**Consultation Response from KC,  
Highways Development Management****2024/92351 Whinney Close Farm, 106, Cockley Hill Lane, Kirkheaton, Huddersfield, HD5 0PF****Erection of detached dwelling and associated landscaping****Date Responded: 15/10/2024.****Responding Officer: D. Stainsby****Responding Ref: K11-14/3**

The proposal is for the demolition of the existing dwelling and the erection of a detached dwelling at Whinney Close Farm, 106, Cockley Hill Lane, Kirkheaton, Huddersfield, HD5 0PF.

Figure 1.4 Proposed Site Plan (Not to scale)

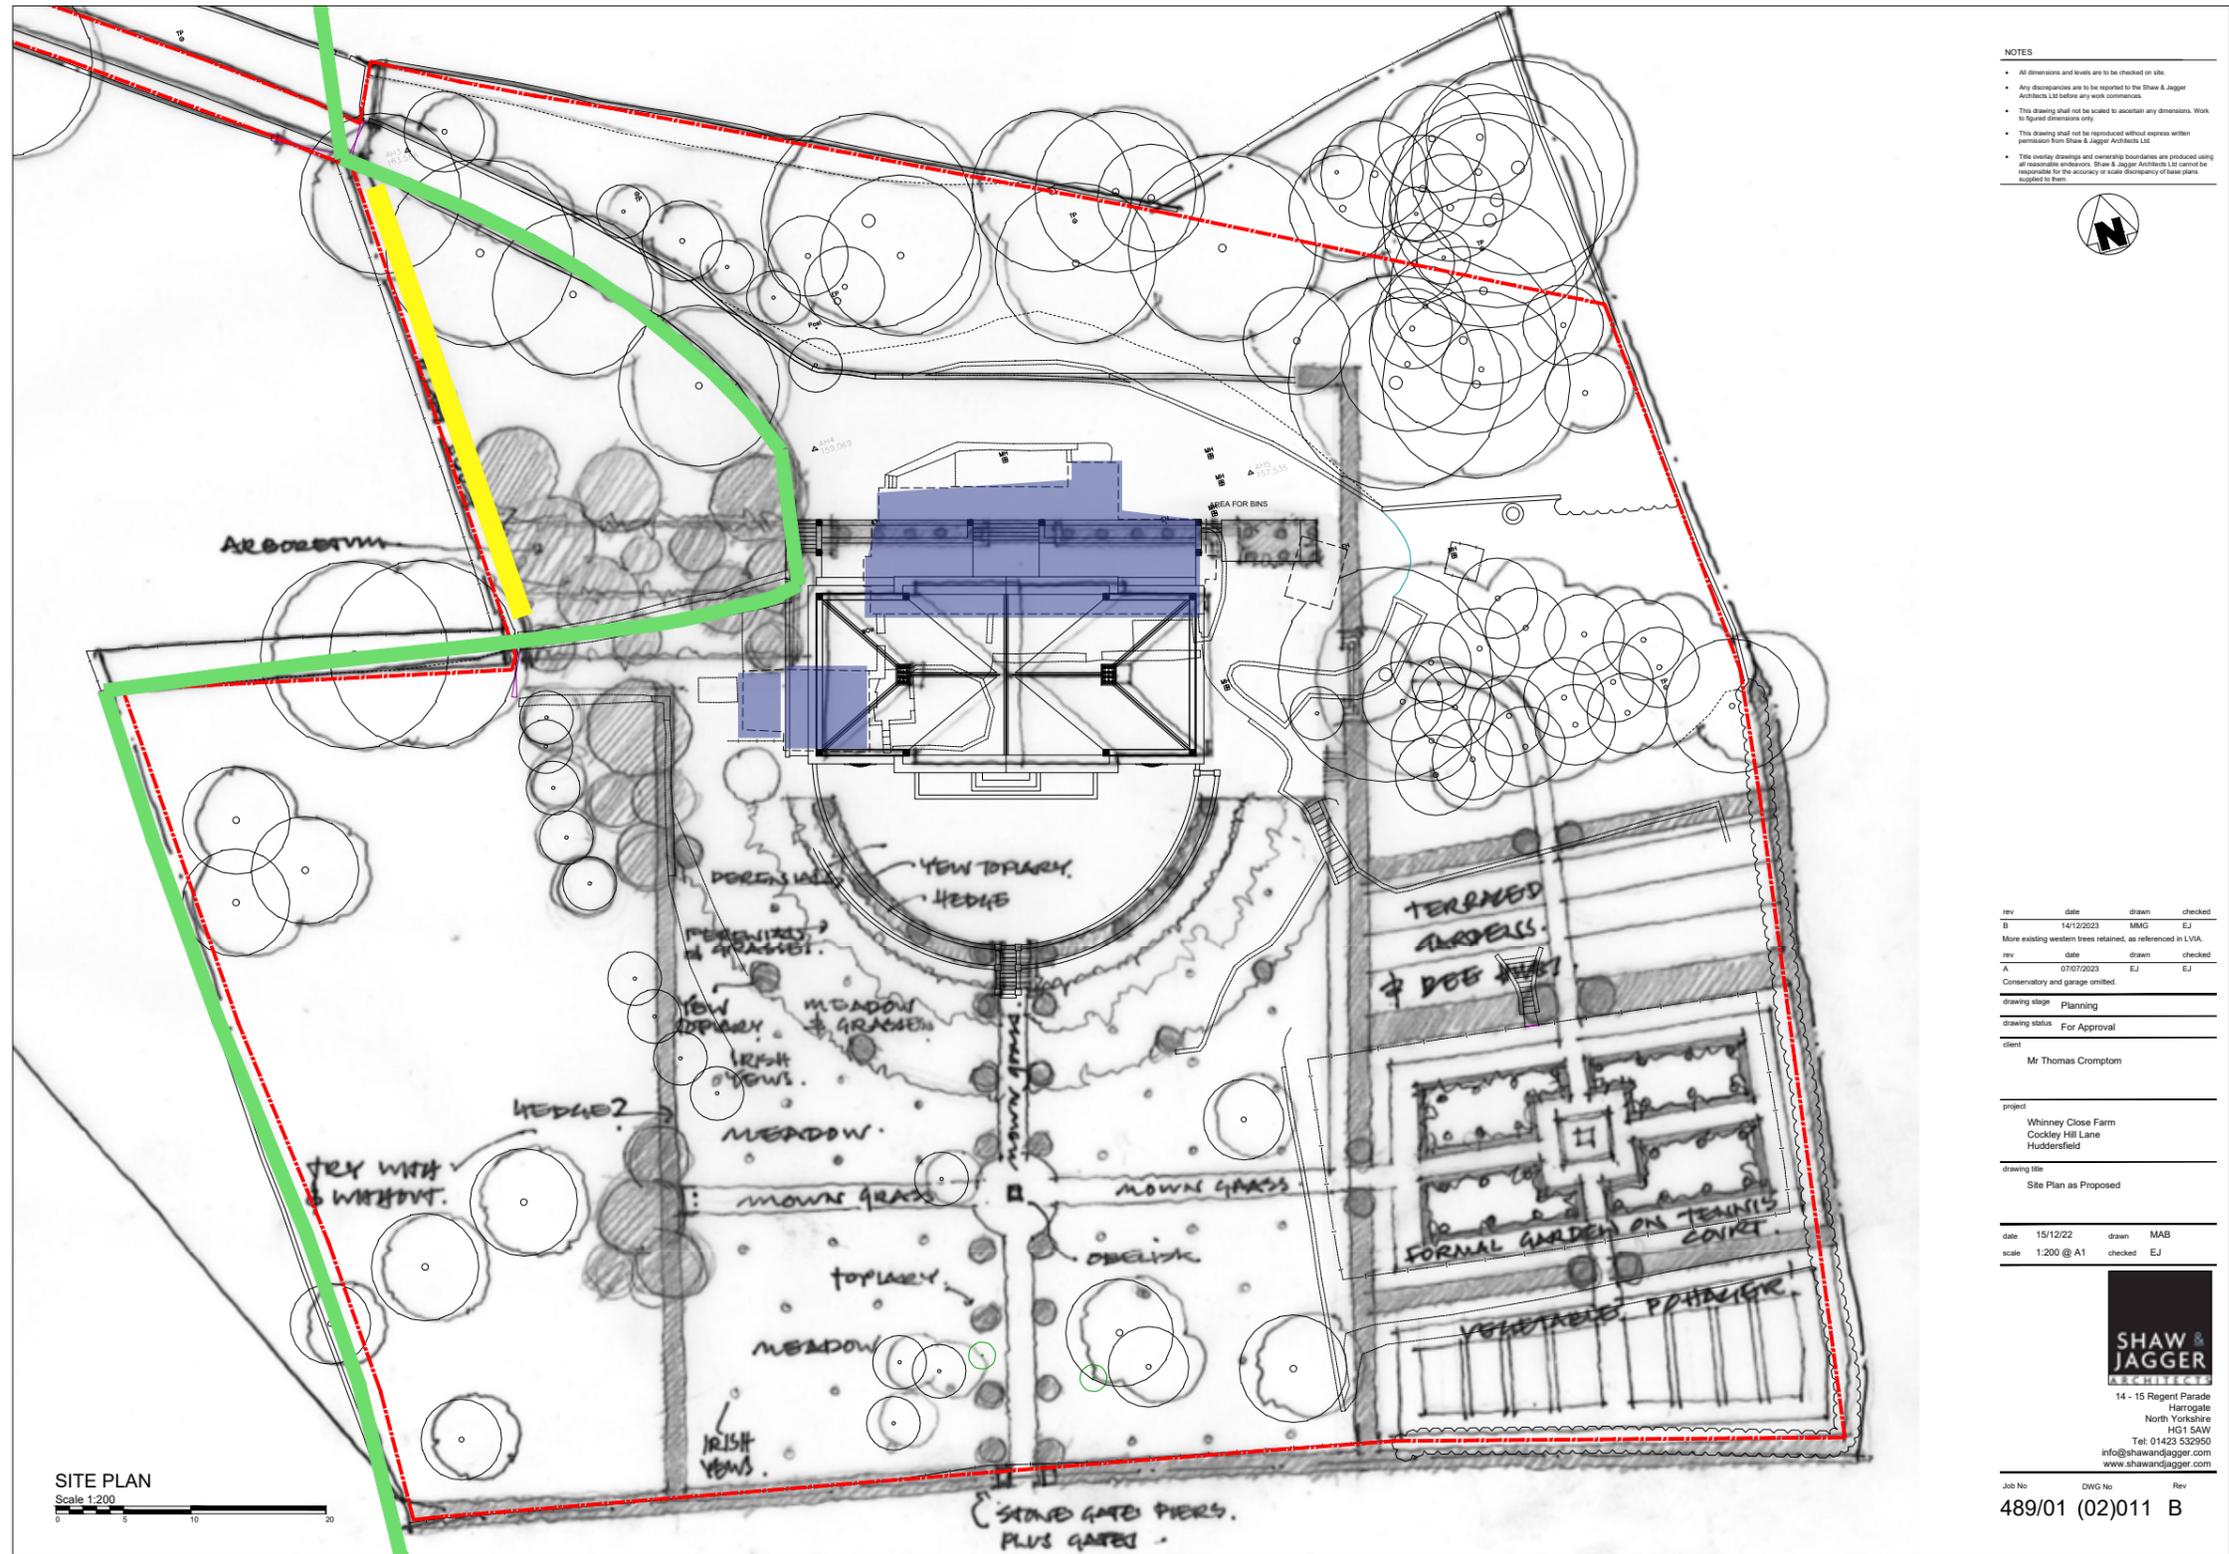
The proposed access uses the existing vehicle access to the site and ample parking is proposed for the dwelling.

Internal turning is available to ensure vehicles can enter and leave the site in forward gear,

There is an existing public footpath which runs along the western boundary of the property and uses the driveway for a short section.

This application proposes to divert the footpath for a short section immediately to the west of the existing house to follow the property boundary.

The Applicant states that Council's footpath officer has been consulted prior to the submission of this application and has no objections to the proposed footpath diversion. However, full consultation with the Council's Public rights of way team to carry out this work will be required.

The approved vehicle parking areas will need to be surfaced and drained in accordance with the Communities and Local Government; and Environment Agencies 'Guidance on the permeable surfacing of front gardens (parking areas)' published 13th May 2009 (ISBN 9781409804864) as amended or superseded.
